OXFORDSHIRE COUNTY COUNCIL'S RESPONSE TO CONSULTATION ON THE FOLLOWING DEVELOPMENT PROPOSAL

Application no: 22/00747/OUT

Proposal: Outline planning application for the development of up to 370 homes, public open space (including play areas and woodland planting), sports pitches and pavilion, drainage and engineering works, with all matters reserved (appearance, landscaping, layout and scale) except for vehicular and emergency accesses to Bicester Road.

Transport Schedule

| Appendix D – Walking / Cycling Routes

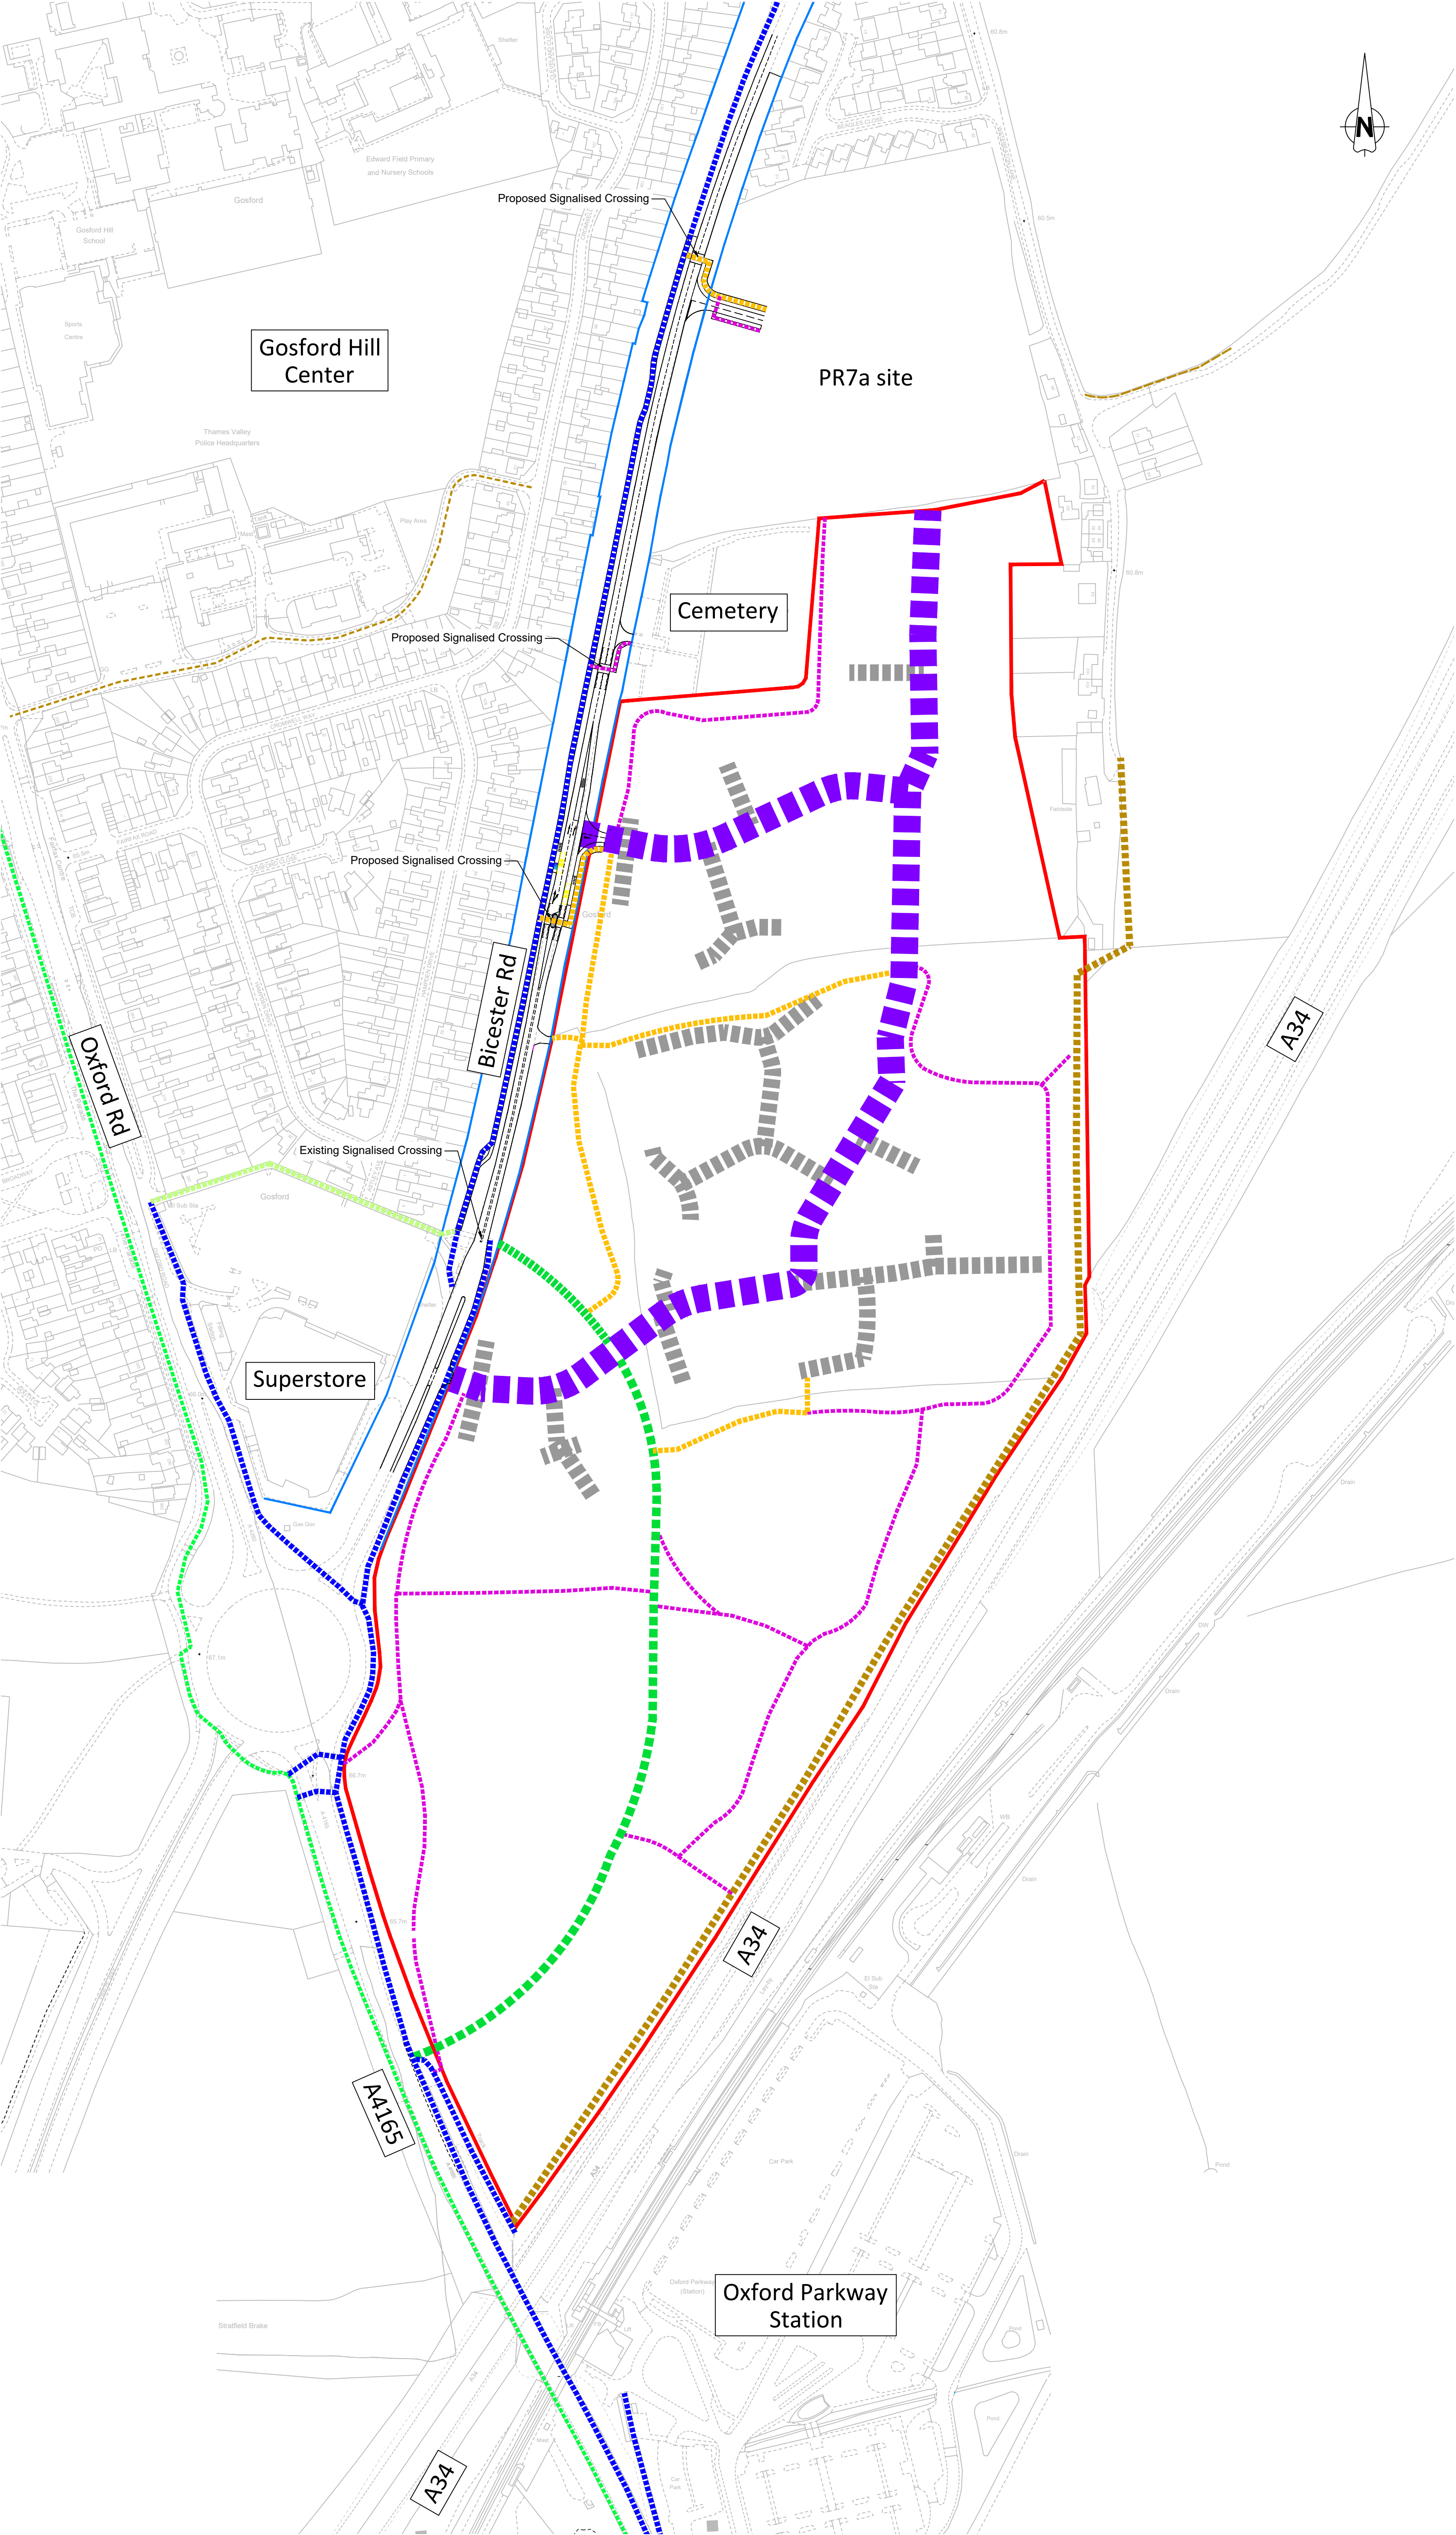
The level of detail on how the Greenway, PRow would link into the existing shared pedestrian/ cycleway along Oxford Road remains unresolved. While *Para 3.8* suggests that these shall combine to a comprehensive network, this stage of application requires to see how. First, the transition between the development and the shared pedestrian/ cycleway facility along Oxford Road needs to be understood acknowledging the level difference. Again, because this matter is part of the access arrangements, it shall not be left to be addressed at the detailed design stage as *Para 3.9* asserts. **(Reason for objection)**
